OXFORDSHIRE COUNTY COUNCIL'S RESPONSE TO CONSULTATION ON THE FOLLOWING DEVELOPMENT PROPOSAL

Application no: 16/00263/F-2

Proposal: Demolition of Buildings 485 and 488 and the erection of 43 dwellings with associated parking, infrastructure, landscaping and public open space.

Location: Buildings 485, 488 And Land Surrounding Those Buildings (Dorchester Phase 6)
Heyford Park Camp Road Upper Heyford

### **Proposed levels and drainage layout**

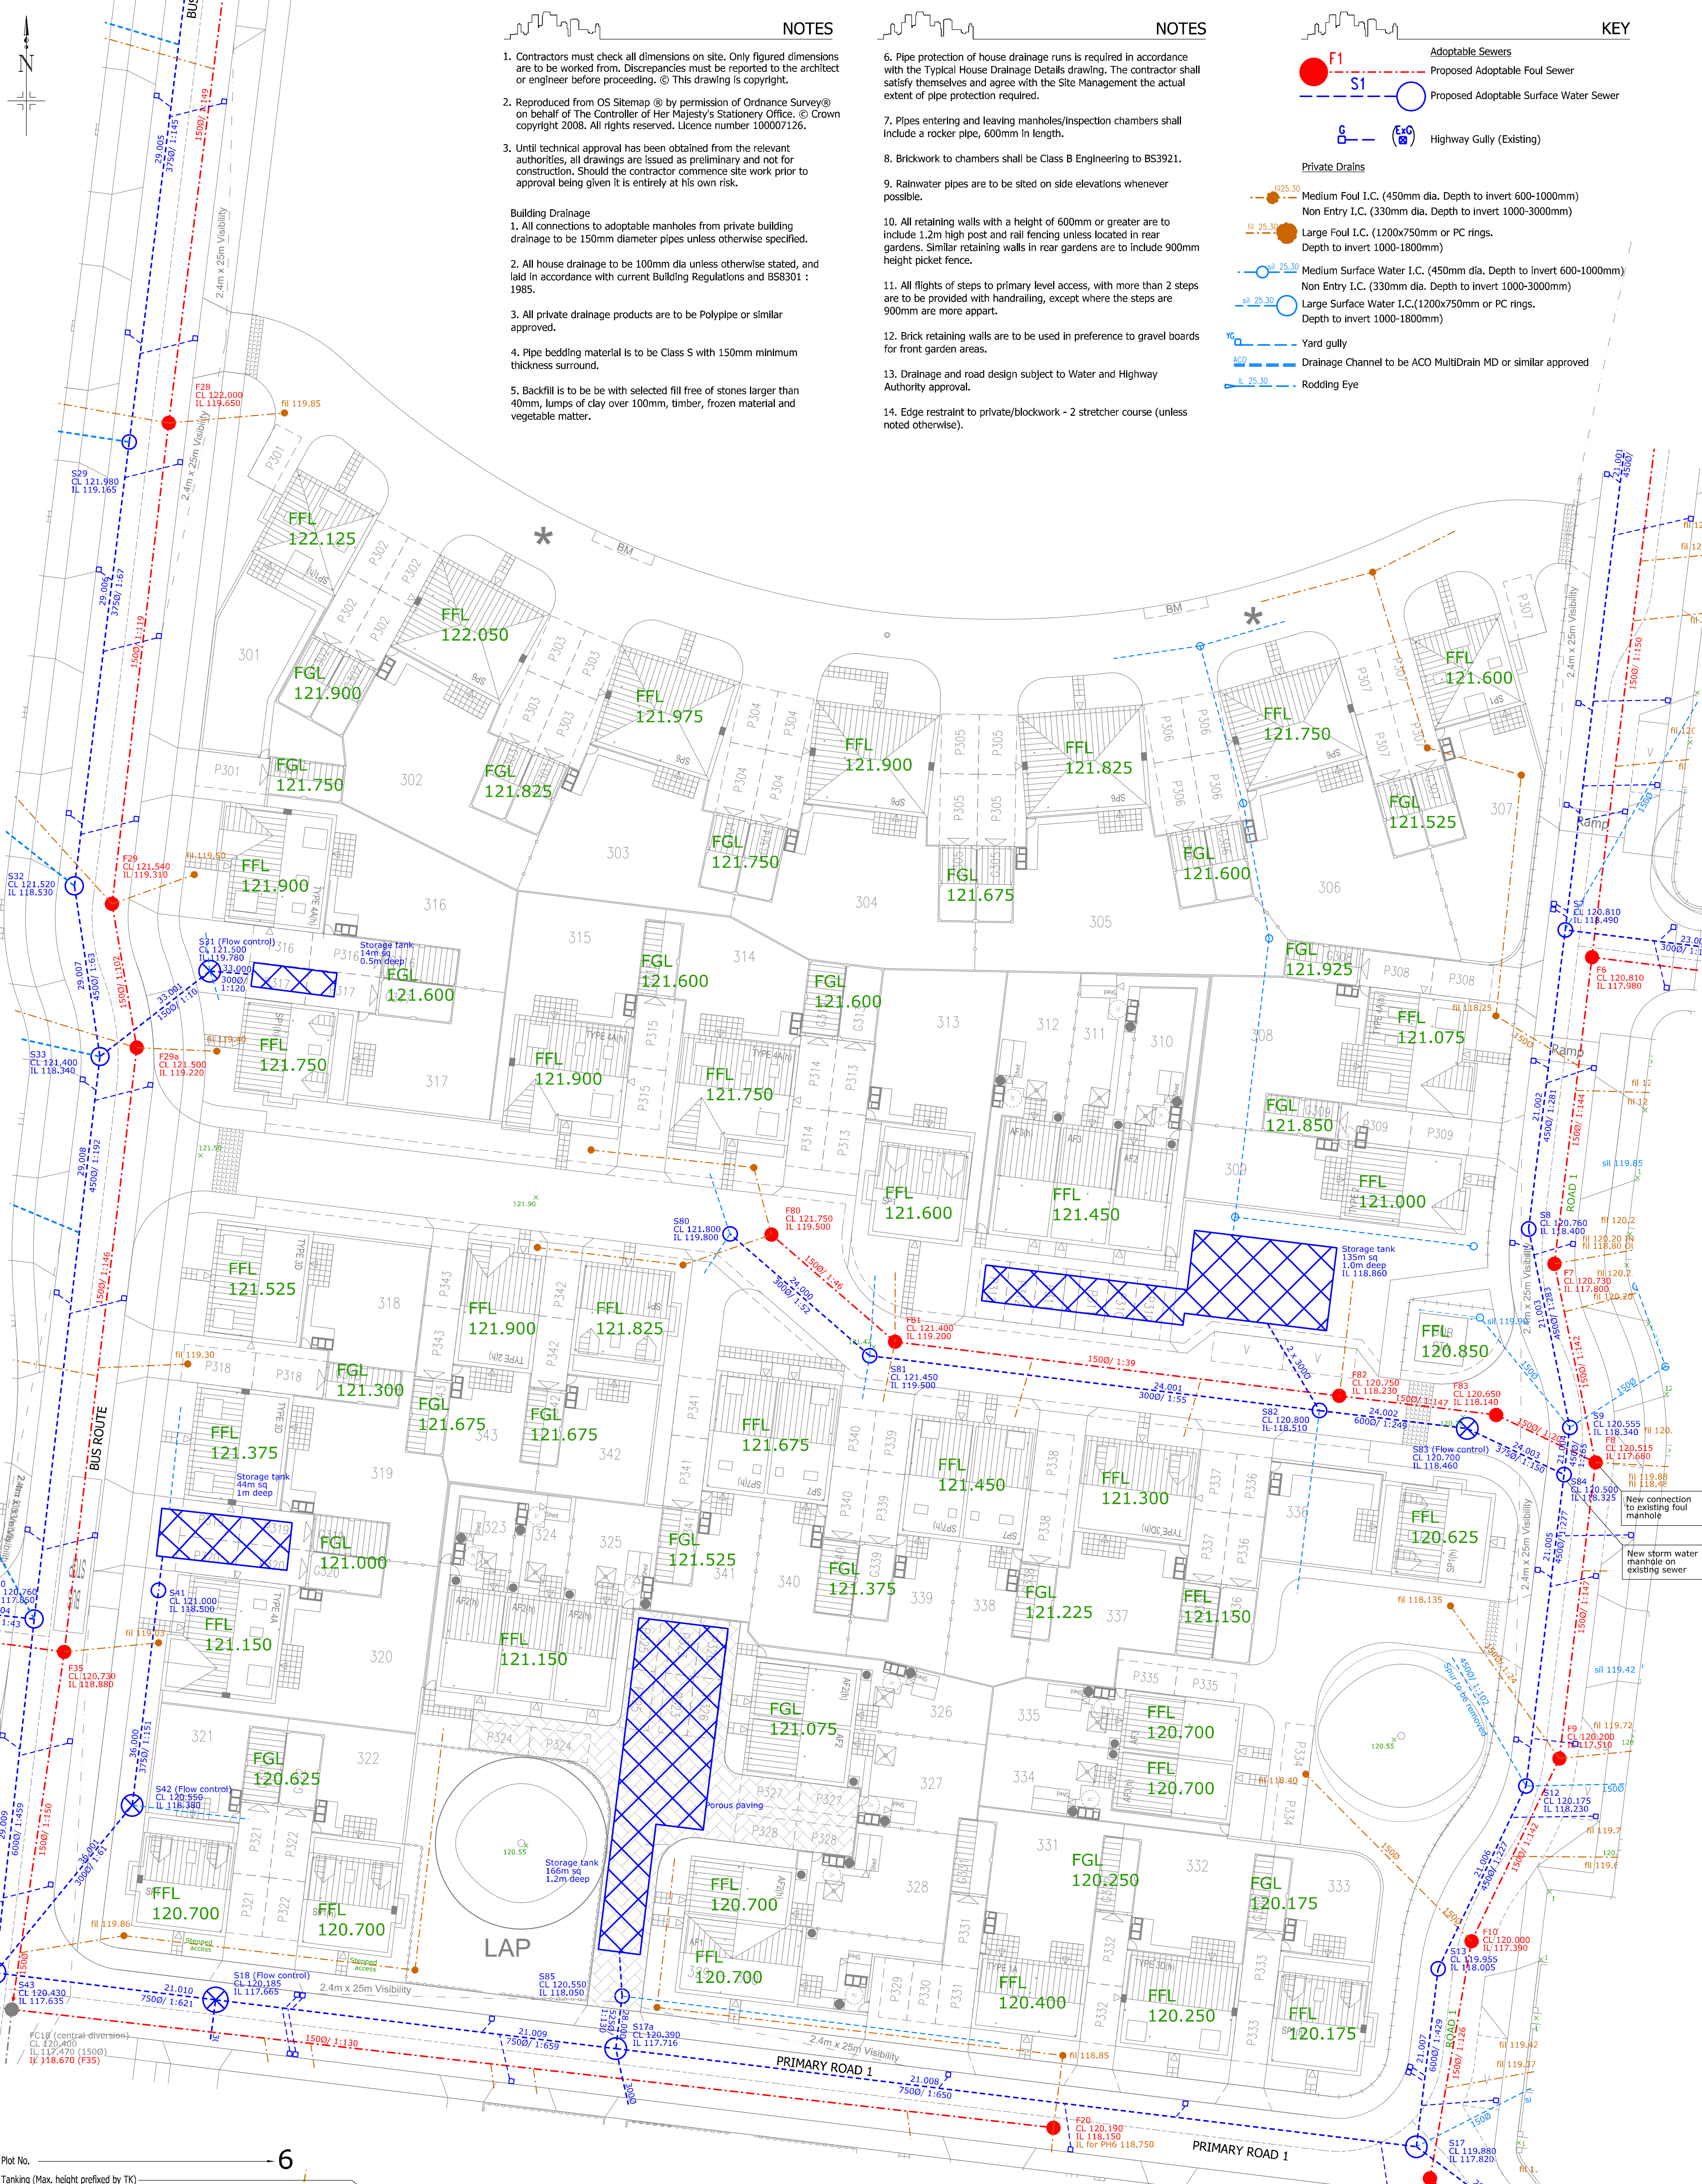
Please provide detailed design of the outfall structure at the Gallos brook including section showing levels.

Please clarify flood route on the development and storage areas. **Reason for objection.**
